Subject: DOCO comments for application 2026/90077- land at Yew Tree Road/Burn Road, Birchencliffe, Huddersfield, HD2 2EQ

Re: 2026/90077- Discharge of details reserved by conditions 2 (materials), 4 (footway), 8 (temporary waste), 9 (bin storage arrangements), and 11 (boundary treatment) on previous permission 2021/91933 for reserved matters application pursuant to outline permission 2018/90776 for erection of 10 dwellings.

Condition 11- boundary treatment

Drawing Title	<b>Boundary Treatments Plan</b>		
Site	<b>Yew Tree Rd (East), Birchencliffe</b>		
Scale	1:500 @A2	Date	25/03/25
Drawn	VB/MC	Checked	MC/BB
Drawing No.	Z234.007	Rev.	-
Thorpe Arch Grange Walton Road Thorp Arch LS23 7BA			
01937 543599 www.newetthomes.co.uk

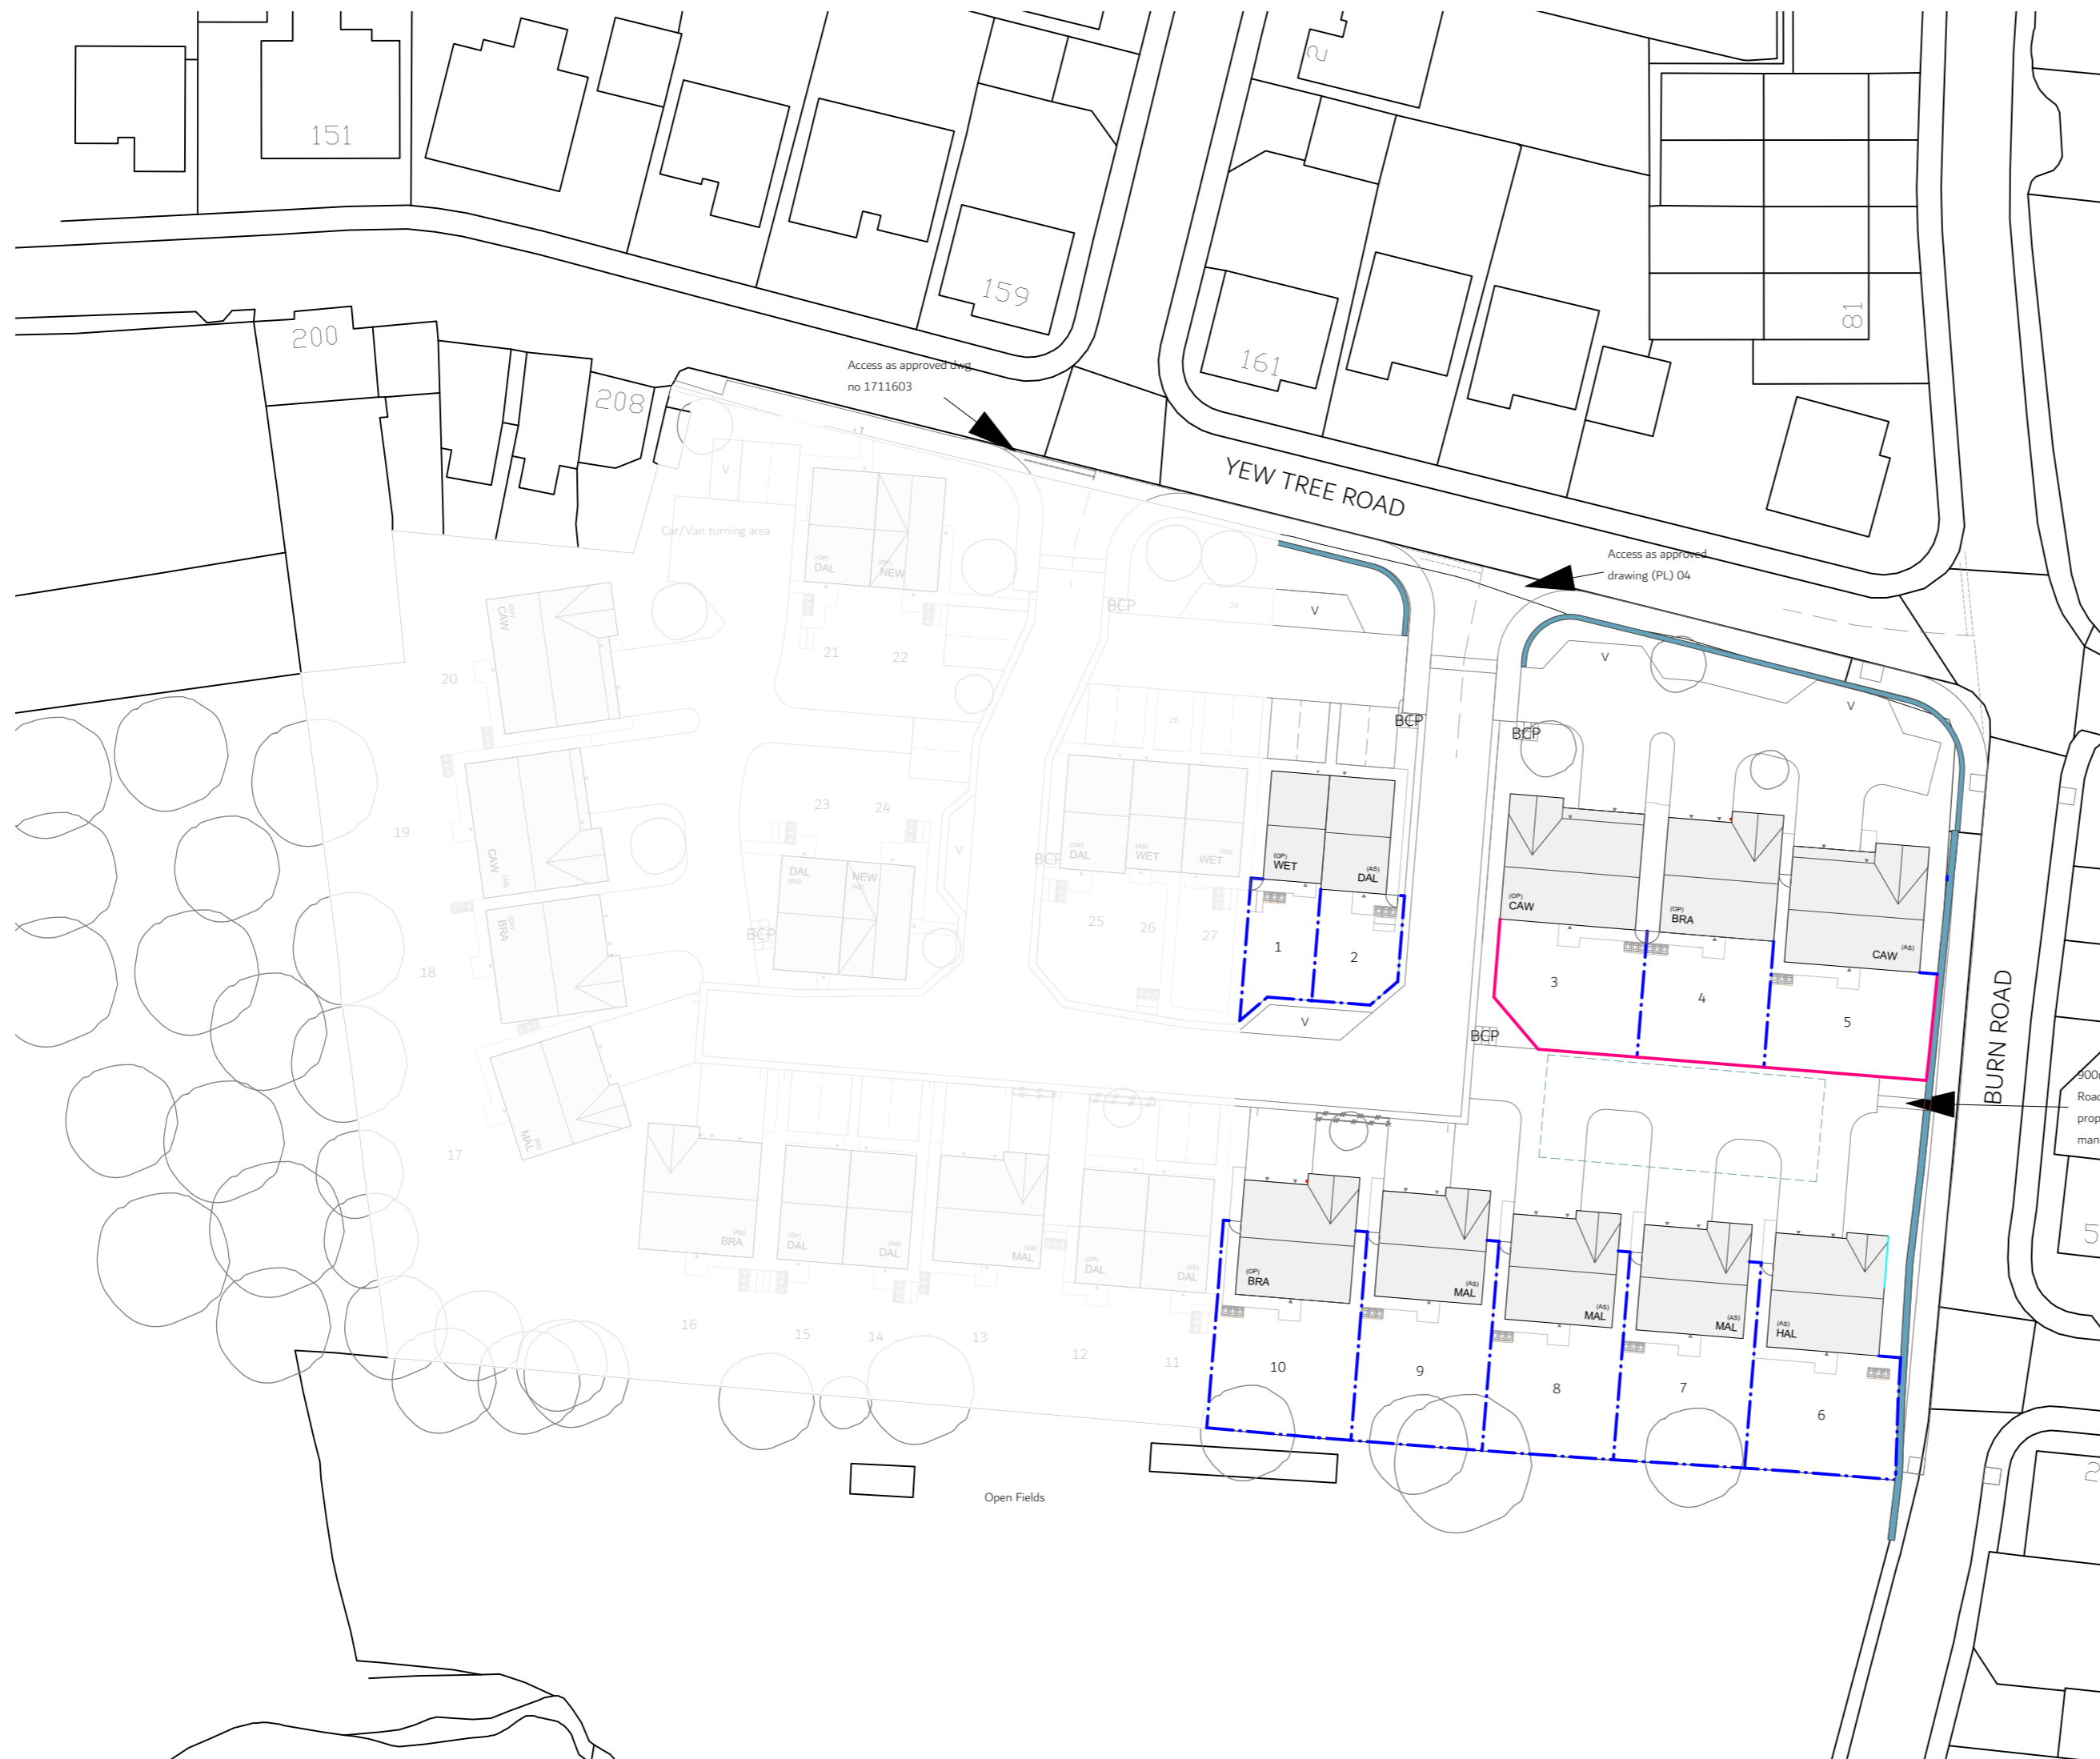
Rear fencing to plots 1 & 2 appears to be missing from the Boundary Treatments Plan (marked with red arrows below) but both are shown fully enclosed with 1.8m close boarded fence on the more recently revised Site Plan. The condition can be discharged provided that all private gardens are secure and protected by 1.8m high boundary treatments.
